# CITY OF PORTLAND, MAINE

March 29, 2018

Project Name:	Mixed Use Building	Project ID:	2017-285
Address:	147-155 Washington Avenue	CBL:	012 G001001
Applicant:	Diving Rock LLC		
Planner:	Shukria Wiar

**Subject:** B-1 Design Review – 155 Washington Avenue  
**Written by:** Caitlin Cameron, Urban Designer  
**Date of Review:** Tuesday, March 6 2018

LANDSCAPING DETAILS
PROJECT NAME: 151 WASHINGTON AVE. REDEVELOPMENT
CLIENT: DIVING ROCK, LLC
15 HOWARD STREET, PORTLAND, ME 04101

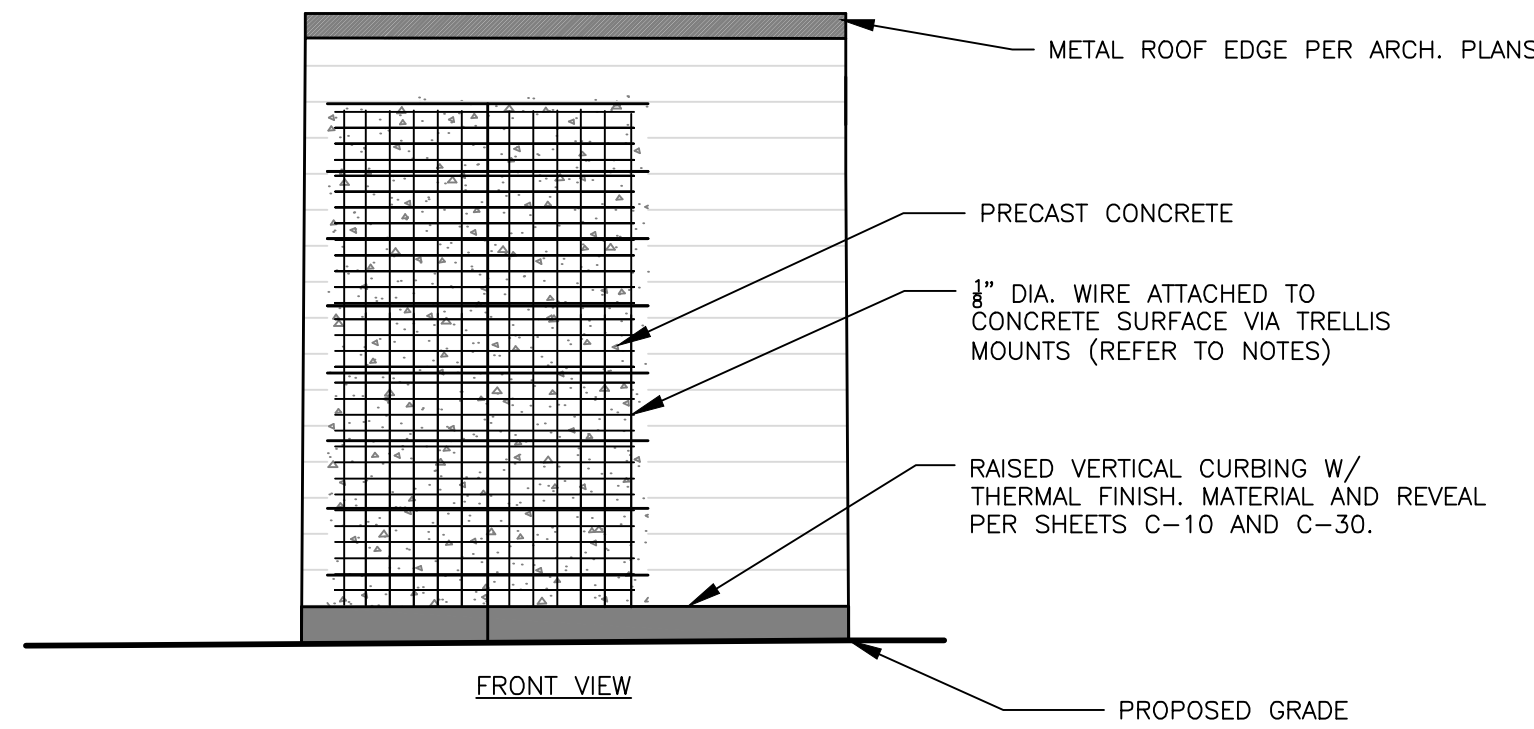
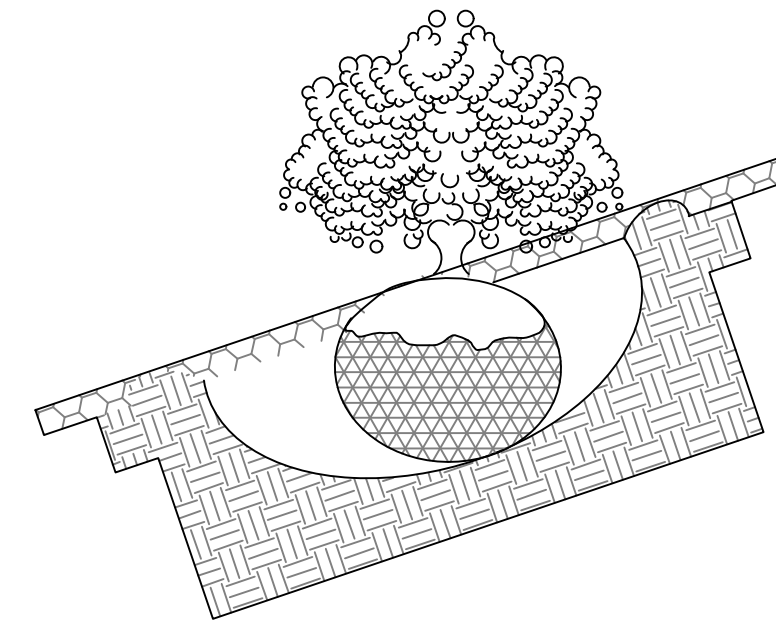
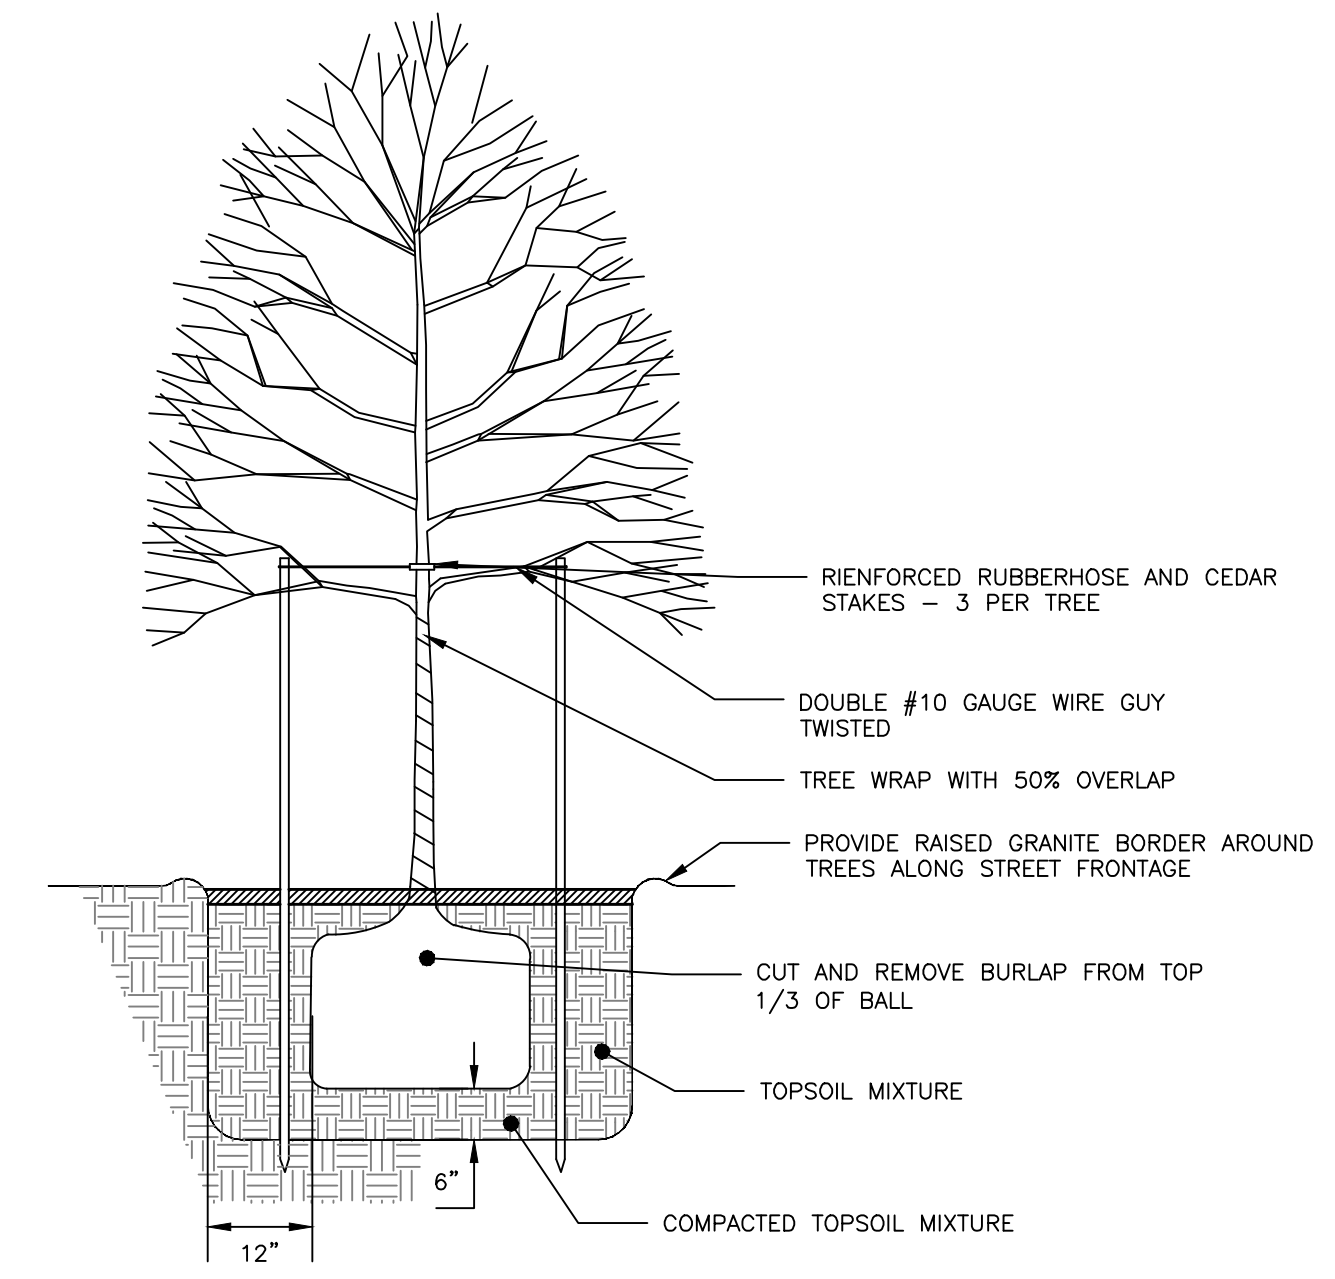
a) Street trees - none proposed, would like to replace the missing tree and perhaps add a second one. The spacing would be between the proposed on-street parking spaces.

Rectangular shaped tree pit, with no tree grate or raised granite planter.

Recommended tree type ornamental due to overhead utilities, Species type include: 'Accolade' or 'Pink Flair' Cherry, or 'Adirondack' Crabapple.

b) Red Maple, on the right side of the building should be an upright shaped cultivar like, 'Armstrong' or 'Bowhall' Red Maple.

c) Landscape elements - Juniper virginiana (7) on the right side of the building, and on [East Cove Street \(4\)](#) these plants should be of a larger size than proposed 5 gal. Recommend 5 - 6' Height, 4 - 5' minimum.

Landscape planting near Dumpsters - the proposed treatment is 50 Panicum (Switch grass). It would be recommended to use perhaps 22 grasses in the snow storage area and include woody tree(s) or shrubs near the back of the dumpster for more year around and taller screening. Overall this space seems to have just a LOT of grasses as an easy fix vs optimize the space with some creativity and interest.

1 WEST EXTERIOR ELEVATION
N.T.S.

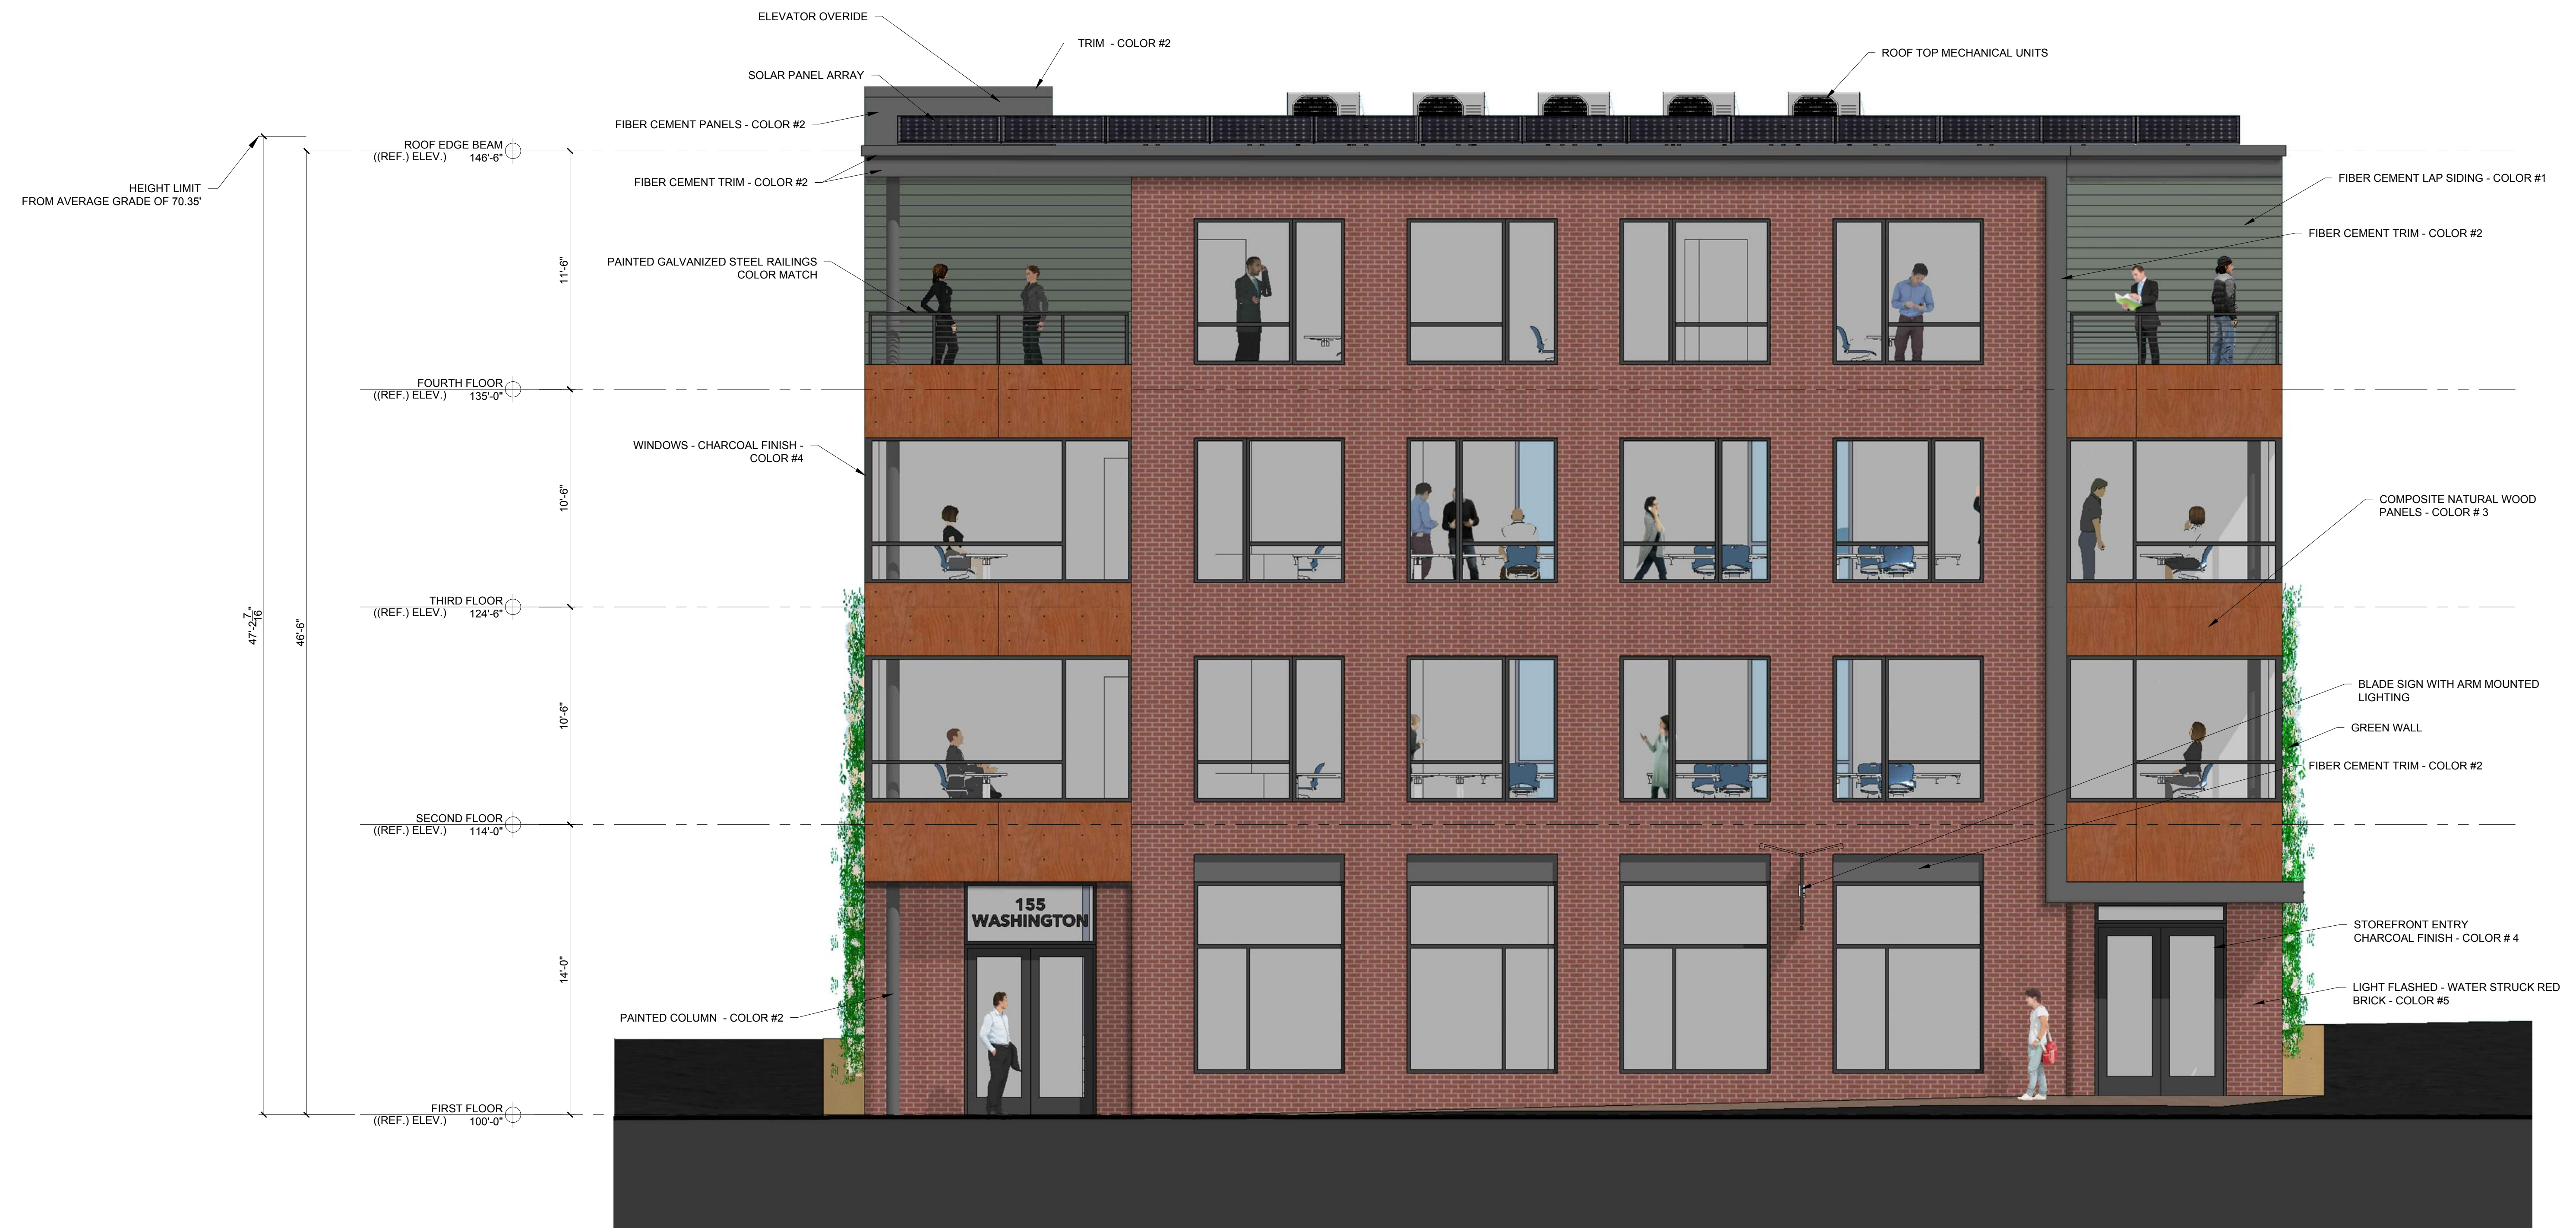
*Standard (1) d. Windows* – Windows are provided along street frontage as required – high level of fenestration. **VT of .7 or greater is required.**

*Standard (1) e. Façade Character* – Building has two entrances facing the street as well as retail storefront adjacent to the street. Blade sign placement should be as near the retail entrance as feasible to differentiate the retail from the office entrances.

*Standard (1) f. Building Design* – Building design conveys its commercial/mixed use nature. Use of brick and storefront is consistent with commercial buildings on this street – though many existing commercial buildings on Washington Ave are converted from different uses. Emphasis to the vertical members at the ground floor is created by the recess of the panels below the windows. **Staff suggest this treatment either be applied to the full height of the building, or at the ground floor only to delineate the different uses. The current design suggests the first and second floor are apart from the upper floors – instead, a more typical approach to the transom of the ground floor retail would be a strong horizontal line created by a lintel or transom or similar element to tie the ground level together and separate from the floors above. The ground floor windows may need to be shortened to achieve this effect.**

*Standard (1) g. Building Materials* – Given the predominant context of simple material palette, staff found the building to include **too many materials** and that material **placement is not helping the overall proportion and massing of the building. The red brick is incongruous with the wood tone corners. Possible revision may be a grey brick with the natural tone, or that the natural tone be grey with the red brick.** Articulation details include the canopies, recessed
